OUT21/5670

**Hunter Power Project (Kurri Kurri Power Station) (SSI-12590060)
Environmental Impact Statement (EIS)**

Attachment A

Detailed advice to DPIE Planning & Assessment regarding the Hunter Power Project (Kurri Kurri Power Station) (SSI-12590060) Environmental Impact Statement (EIS)

Figure 5.1: Indicative depths of excavations and groundwater (two scenarios)

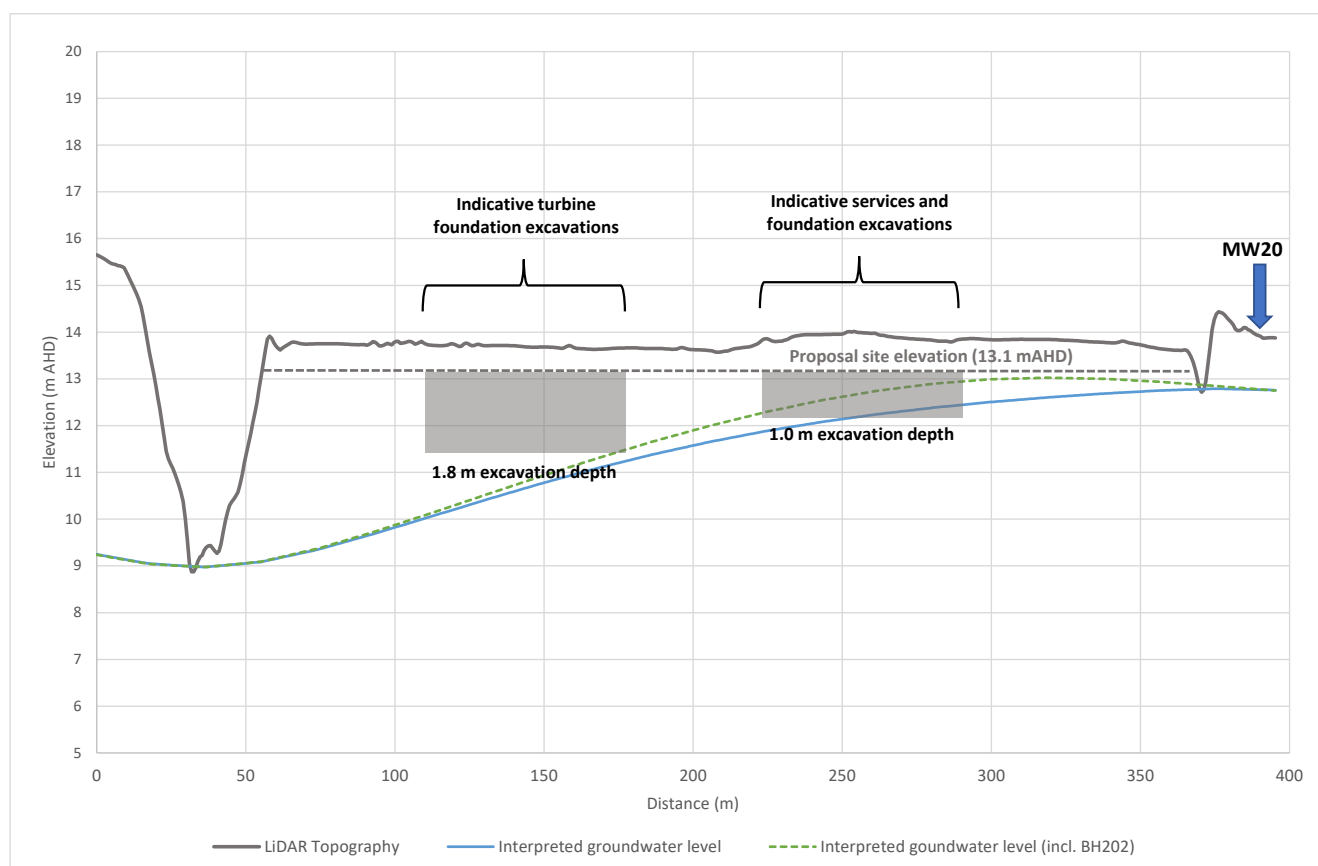
Groundwater levels vary across the site between 1.2 – 4 metres below ground level and, based on the proposed design, interception of groundwater is inferred during construction of bored piles (approximately 18m in depth), a stormwater basin, and some footings, and the proponent asserts that '*significant inflow or requirement for substantial dewatering is unlikely*'.

DPIE Water notes that a quantified estimate of groundwater inflows during construction was not provided, however, information presented in Table 12.3: *Groundwater mitigation measures*, suggests the proponents is planning a subsequent body of work, potentially including a dewatering plan. This suggests the proponent does not currently have sufficient confidence in the estimate of the volume of take to adequately assess potential impacts during construction.

The proponent intends to adopt '*means to minimise water ingress during construction*' of a stormwater basin and other services with potential for intercepting groundwater. Consideration should also be given to preventing seepage and/or ingress during construction and operation to prevent contamination of groundwater or unnecessary take.

- The proponent should demonstrate a reasonable quantified estimate of groundwater take for the proposed development.
- The proponent should refer to the *Sydney Basin-North Coast Groundwater Source* of the *Water Sharing Plan for the North Coast Fractured and Porous Rock Groundwater Sources 2016* in the Response to Submissions and any future documents.
